National Highways Planning Response (NHPR 21-09) Formal Recommendation to an Application for Planning Permission

Council's Reference: 23/03428/OUT **National Highways Ref:** NH/23/04172

Location: OS Parcel 7921 South Of Huscote Farm And North West Of County Boundary Daventry Road Banbury

JOB TITLE		LAND AT M40 J11		CLIENT		GREYSTOKE	
DRAWING TITLE							
A361 ROUNDABOUT WITH SECONDARY ACCESS							
SCALE	DRAWN BY	DATE	DRAWING No	REVISION			
1:1000@A1	RM	04/12/23	23457-07-01GA	C

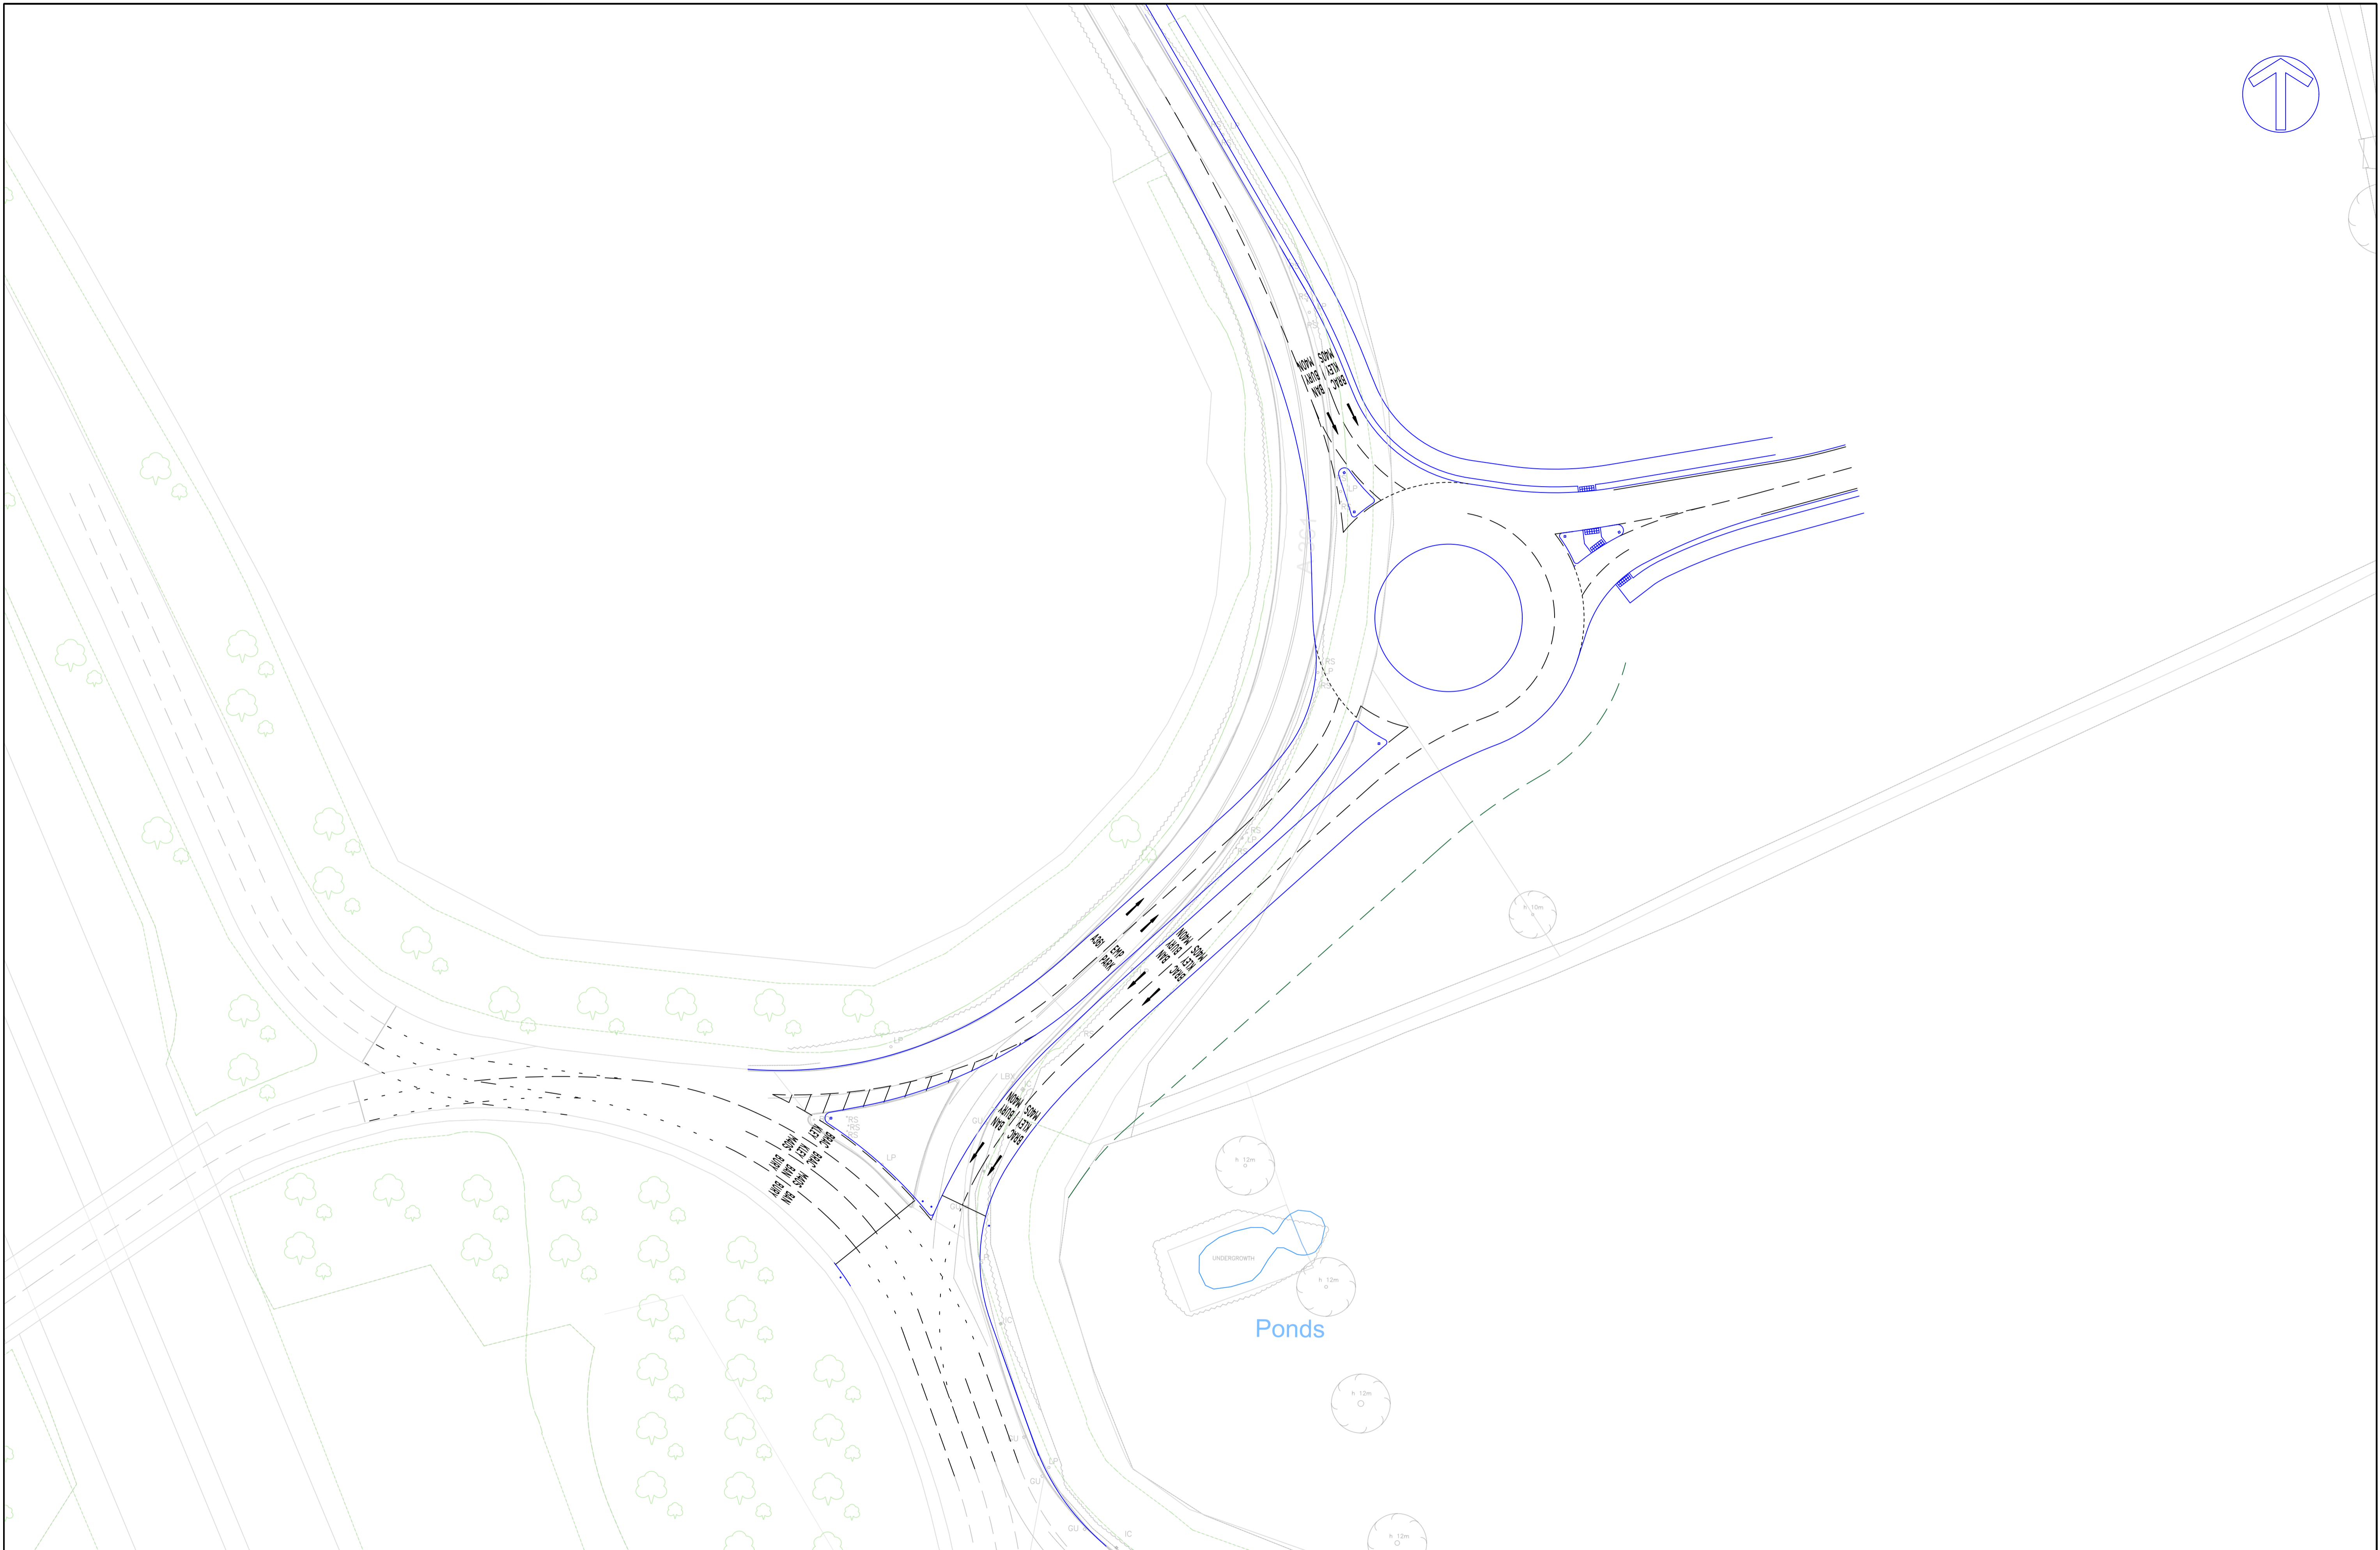
National Highways has a particular concern that the proposed location of the site access roundabout on the A361, could result in peak hour traffic queuing back onto M40 Junction 11. The LinSig modelling is unable to assess this potential impact and therefore National Highways requires a VISSIM model to determine whether this is likely to be a cause for concern.
